Application No: BE/81/18/PL

Recommendation Report for Planning Permission

LOCATION: 324 Chichester Road
Bersted
PO21 5AU

PROPOSAL: Change of use of the property from dwellinghouse to mixed use dwellinghouse & attached building for the operation of a hairdressing business (A1) & retention of attached building.

Drawing 3 - Proposed Site Plan
Scale 1:200 @ A3

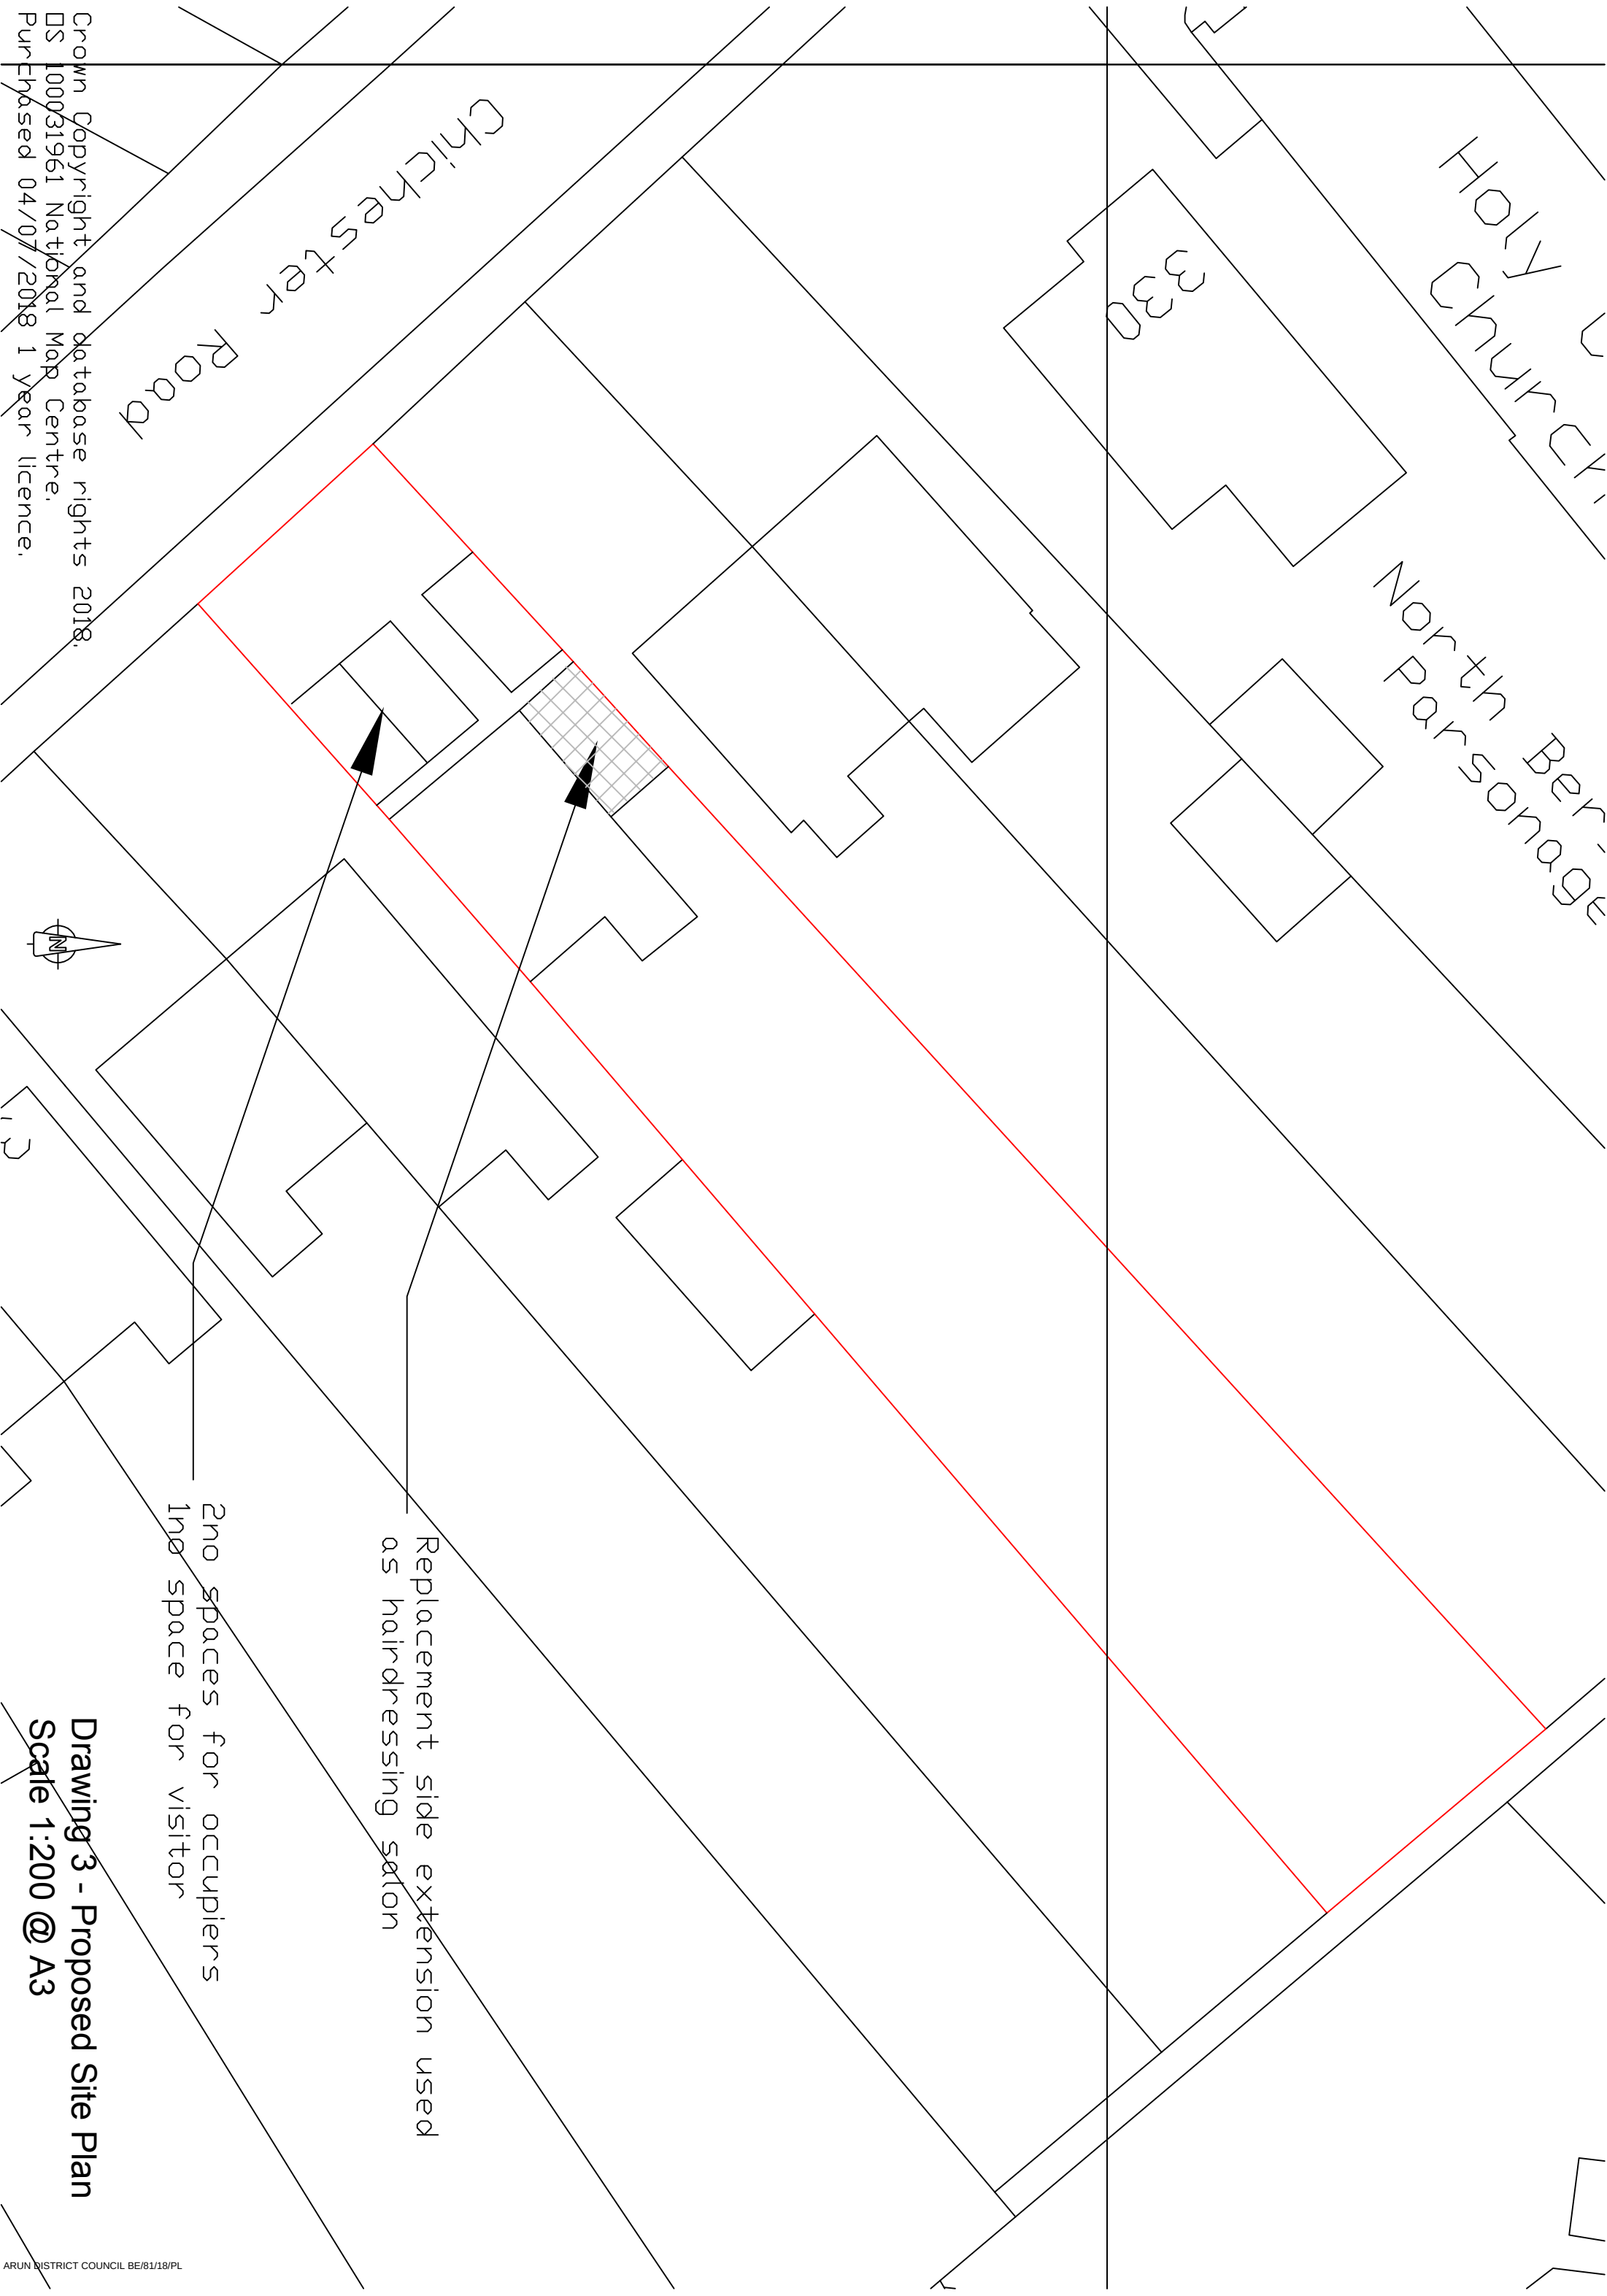
- Cars reversing onto a main road as there is insufficient space for vehicles to turn onsite.
- Setting a precedent for A1 use in a residential area could lead to more intensive use in the future.

- The application states only one customer at a time and one parking space for that customer. This does not provide a parking space for, or take any account of, the next customer.

- The business is in operation already and the next customer is usually parked on the road itself, often encroaching over neighbouring properties' driveway access. Is an obstruction.

WSCC mapping indicates that there is sufficient space on site for three cars to park. The proposed parking provision is anticipated to be sufficient given the nature of the business serving one client at a time.

A turning on site is preferred, however this is an existing practice that has operated on site, without evidence of highway safety concern. Not anticipated to result in a material increase in vehicle movements to or from the site.

1 parking space is proposed for client use. 1 space is appropriate as there would only be 1 client served at any one time.

Objection has been raised by Bersted Parish Council regarding cars reversing onto a main road as there is insufficient space for vehicles to turn onsite.

WSCC Highways have commented that a turn on site would be preferred for the use, however this is an existing practice that has operated on site, and within neighbouring properties for some time without evidence of highway safety concern. This proposal is not anticipated to result in a material increase in vehicle movements to or from the site.

Officers note the loss of the attached garage and when 1 space is in use for clients that parking would be reduced. The loss of a parking space to the front of the dwelling would only be during the limited opening hours and when a client comes by car. The applicants acknowledge that they would have 2 parking spaces for the residential use when the salon is in use and it is expected by that they would not park other cars such as to cause an obstruction. Officers note the limited opening hours and consider there would be sufficient parking available for the off-road parking of cars with regards to the residential use of 324 Chichester Road.

- 6 The car parking spaces proposed shall be constructed within one month of the grant of this permission, in accordance with the approved site plan. These spaces shall thereafter be retained at all times for their designated purpose.

CLIENT		PROJECT		TITLE		STATUS		DRAWN BY		REVIEWED BY	
M SZCZEPANIAK		324 CHICHESTER ROAD NORTH BERSTED		EXISTING FLOOR PLAN AND ELEVATIONS		PLANNING		SJ		SJ	
						DATE		SCALE		DRAWING NUMBER	
						05.02.2019		1:100@A3		ADC/11/18 - 5A

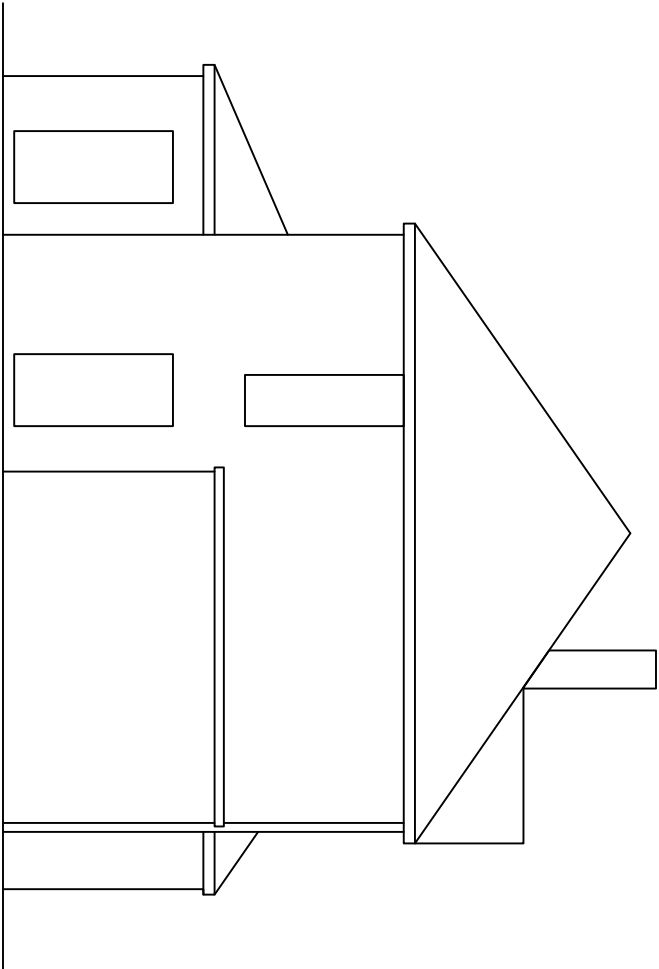
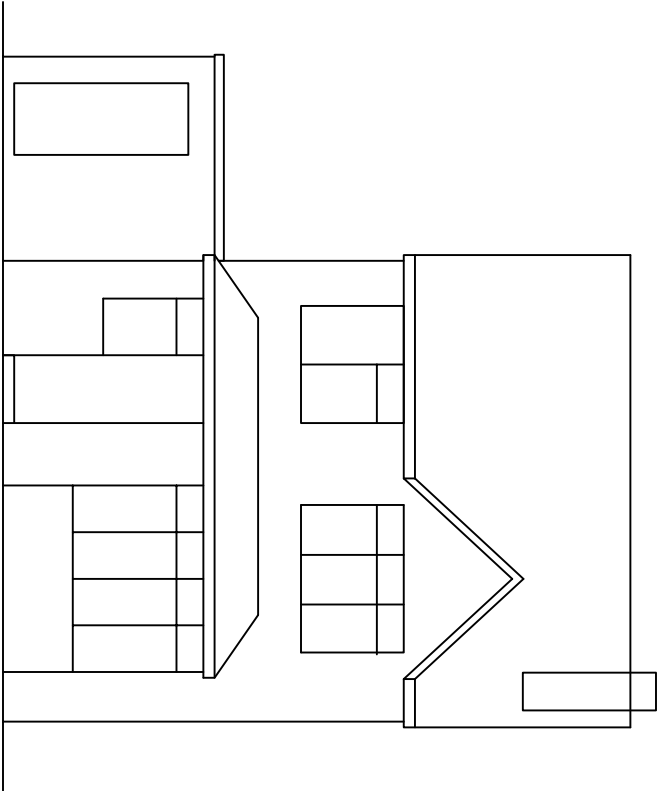
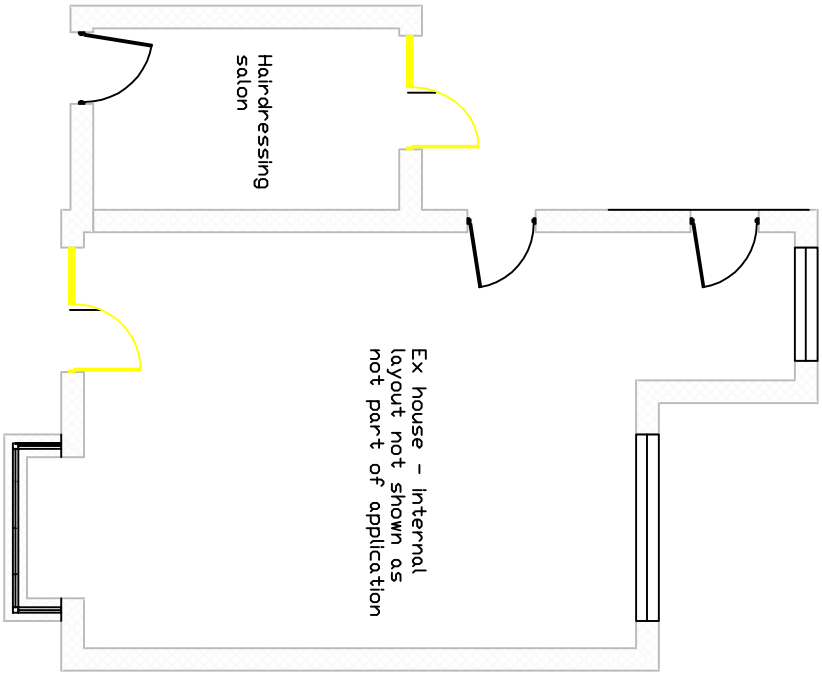
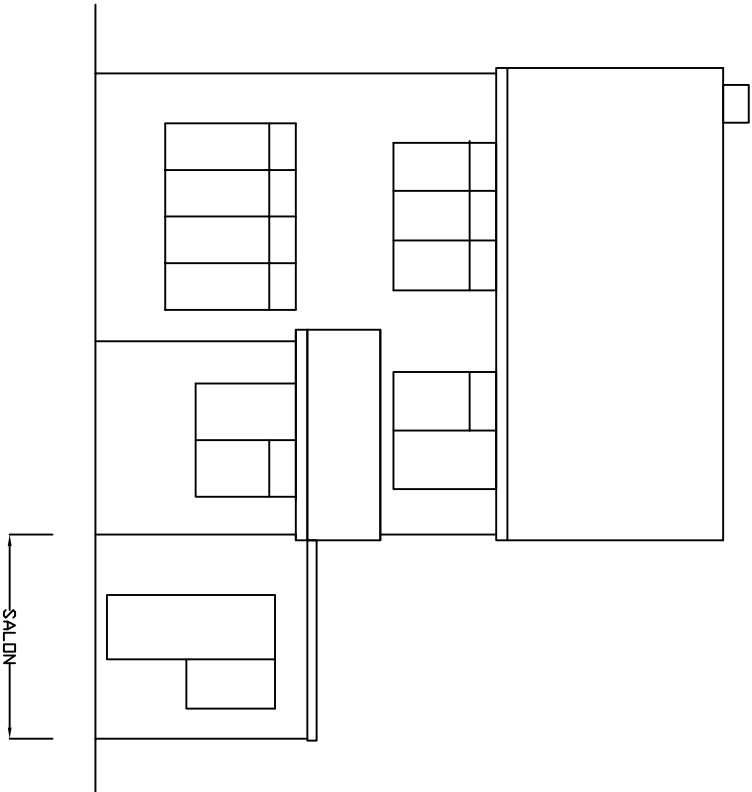
The alterations to the garage do not lead to it being any larger with regard to depth and height. The amended garage would be sited in the same position. The addition of a door to front is deemed acceptable. Officers consider the amended garage (side extension) and its use as a hairdressing salon would not have a detrimental impact on the street scene or wider area.

The proposal not only includes the use of the attached side extension (former garage) as a hairdressing salon but also the partial rebuild to provide the salon with an entrance door at the front and back. There is 1.8m high close boarded fencing along the common boundary of number 326, which mitigates the potential of detrimental overlooking from the window at the rear.

The proposed alterations to the garage do not lead to it being any larger with regard to depth and only slightly higher by approximately 0.25m. The additional height would not have a detrimental impact with regard to overshadowing, overbearing effect and loss of light/sunlight on the occupiers of adjoining properties, in particular 326.
